Arun District Council
Arun Civic Centre
Maltravers Road
Littlehampton
West Sussex BN17 5LF
Planning General Enquiries
Tel: (01903) 737756 Fax: (01903) 730442
Dx: 57406 Littlehampton
Minicom: 01903 732765
e-mail: planning@arun.gov.uk
website: www.arun.gov.uk/planning

Application for approval of matters reserved by conditions imposed under LU/47/11/ (units 6-117) relating to conditions 5 for details of materials & external finishes, 7 appearance, landscaping & layout particulars, 10 Surface Water Drainage Scheme, 11 access to & maintenance of watercourse or culver, 12 discharge of any flows to watercourses or culverting, diversion, infilling or obstruction of any watercourse , 13 Foul Drainage System, 14 landscape & layout particulars, 15 tree protection, 22 Construction Method Statement, 23 details of construction compound, 24 piling or any foundation designs, 25 vehicle cleaning facilities, 26 layout & specifications & construction programme, 30 fire hydrants & 31 details of & timetable for decentralised & renewable energy sources.

Land North of Toddington Lane, Littlehampton,

Arun District Council have decided to **REFUSE details reserved by condition for the following reasons:

SITE	
HAMPTON PARK LITTLEHAMPTON, WEST SUSSEX	
DRAWING TITLE	
ROAD & SEWER SECTIONS	
SHEET 1	
DRAWN BY	DATE
SY	NOV 2015
CHECKED/DATE	
SCALE: 1:100, H=1:500	
REV	DRAWING NO.
B	LITL-503/1

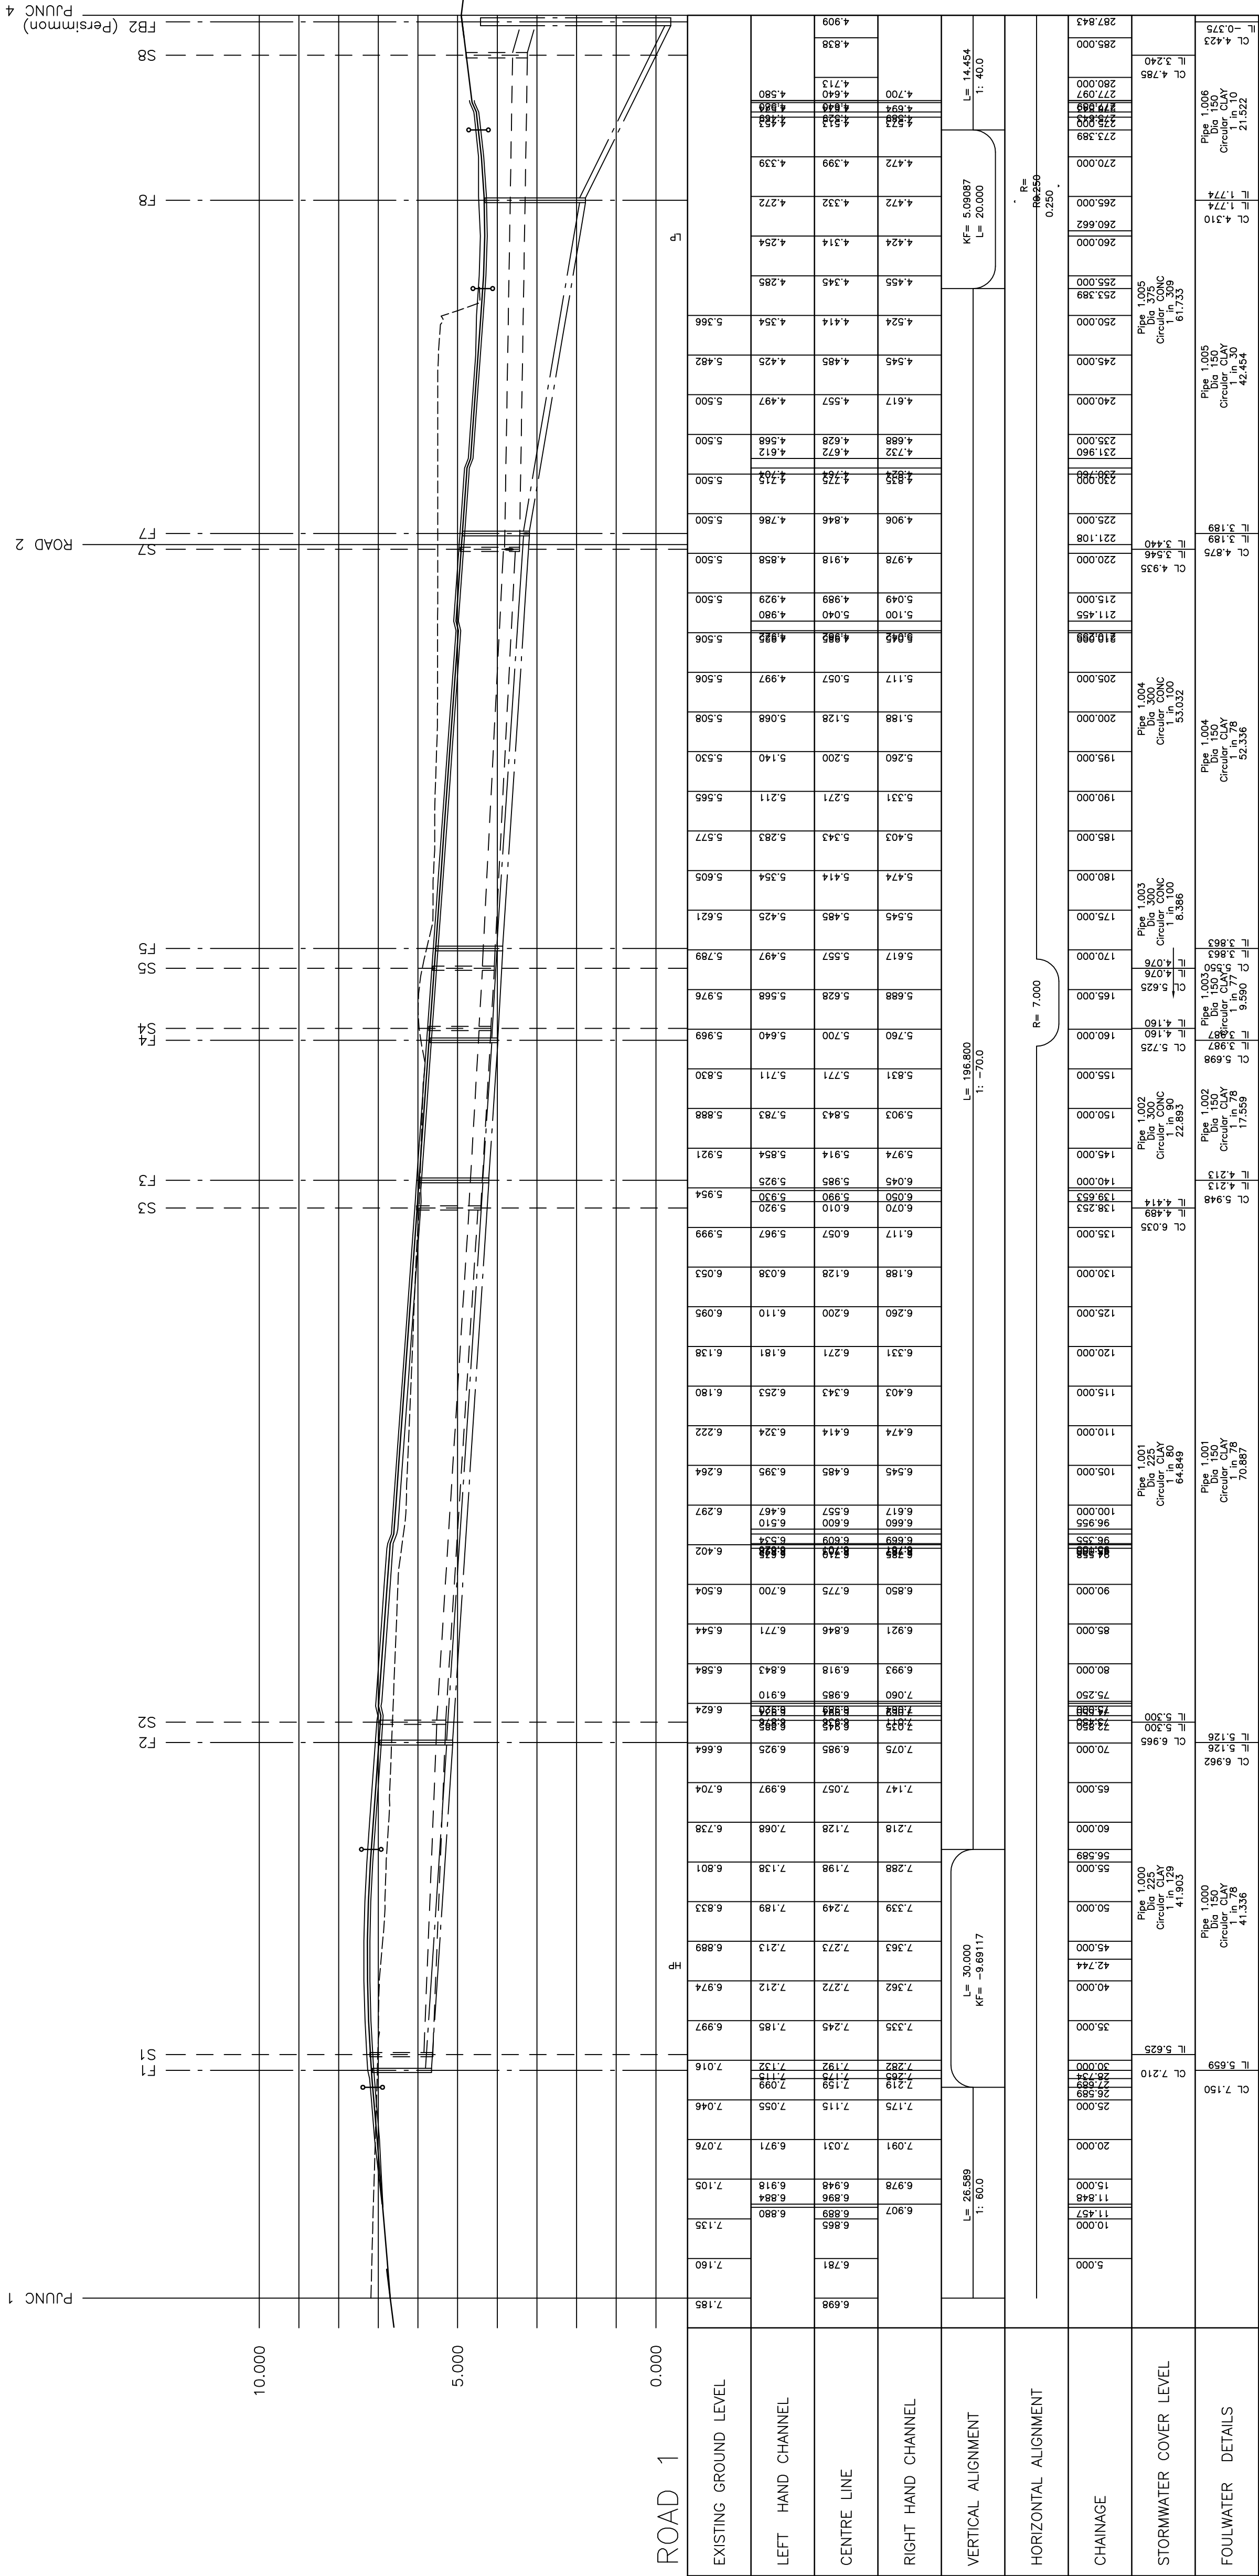
- o Please provide an overlay of each phase on the proposed discharge rate catchment layout, showing it as a proportion of the catchment.
- o Please provide calculations proving that the 1 in 100 year plus 30% climate change event is contained within the surface water attenuation system. And proving that self-cleansing velocity of 1m/s is achieved in all pipes.

- o Please provide construction details of the permeable paving, and manholes.
- o Please update the plans to show:
 - Exceedance flow routes;
 - invert, slope, diameter of all pipes;

DRAWN BY	DATE	NOV 15	DRAWING NO.
NA			LITL-509

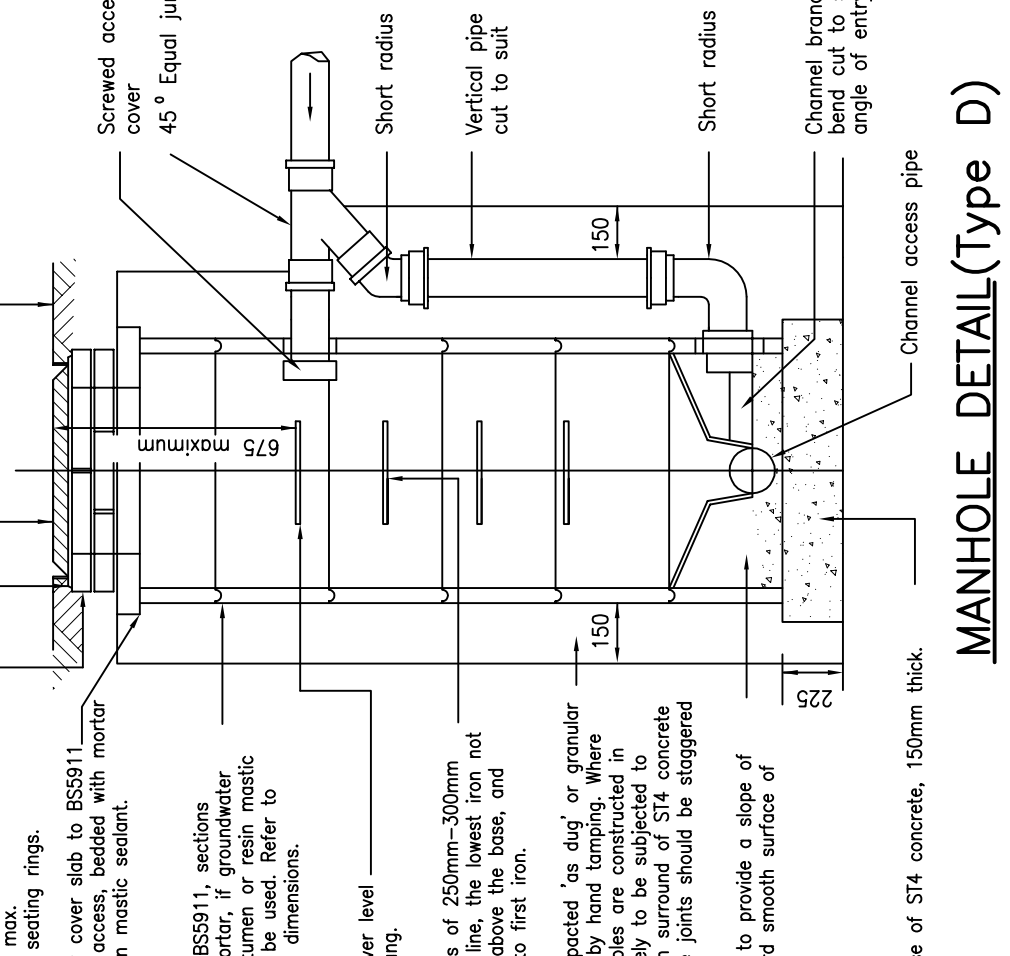
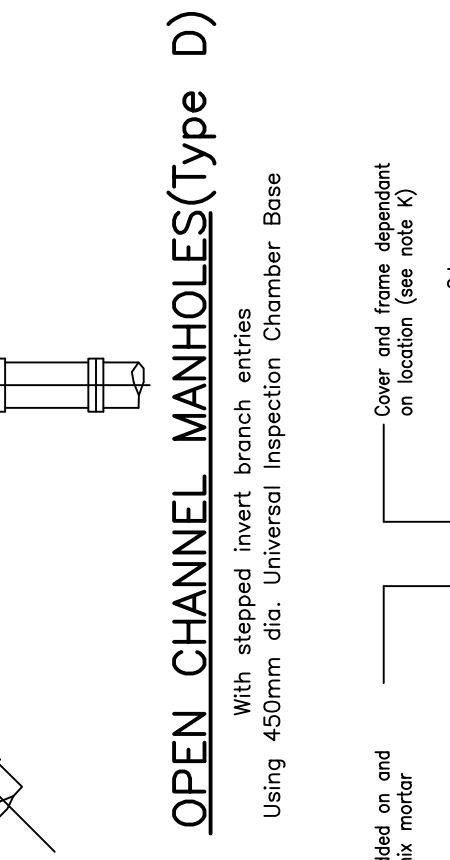
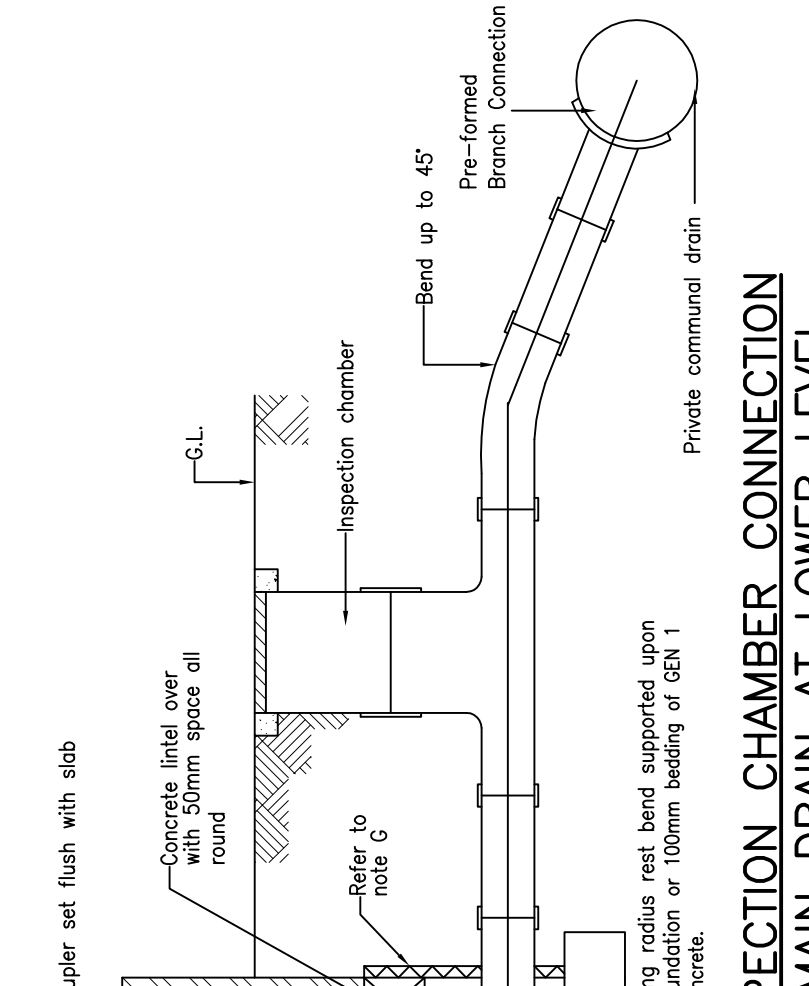
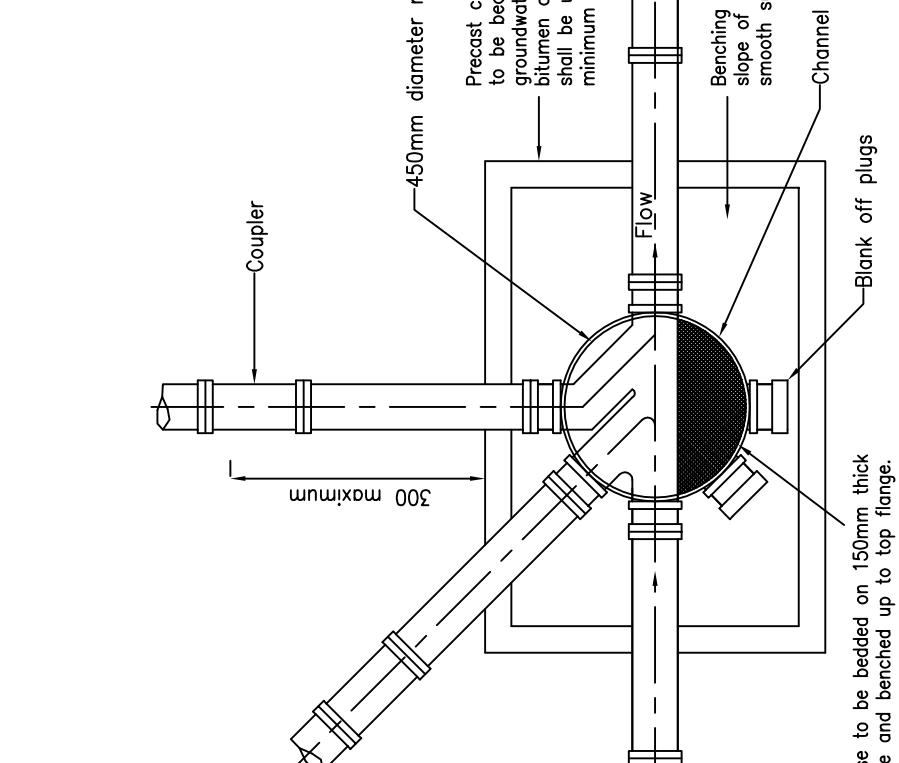
- o Please provide a manhole schedule.
- o We will require details of the full ground investigation report including winter groundwater monitoring and infiltration tests. I note that we only have an abstract of the Ground investigation report supplied with an earlier FRA for the site.
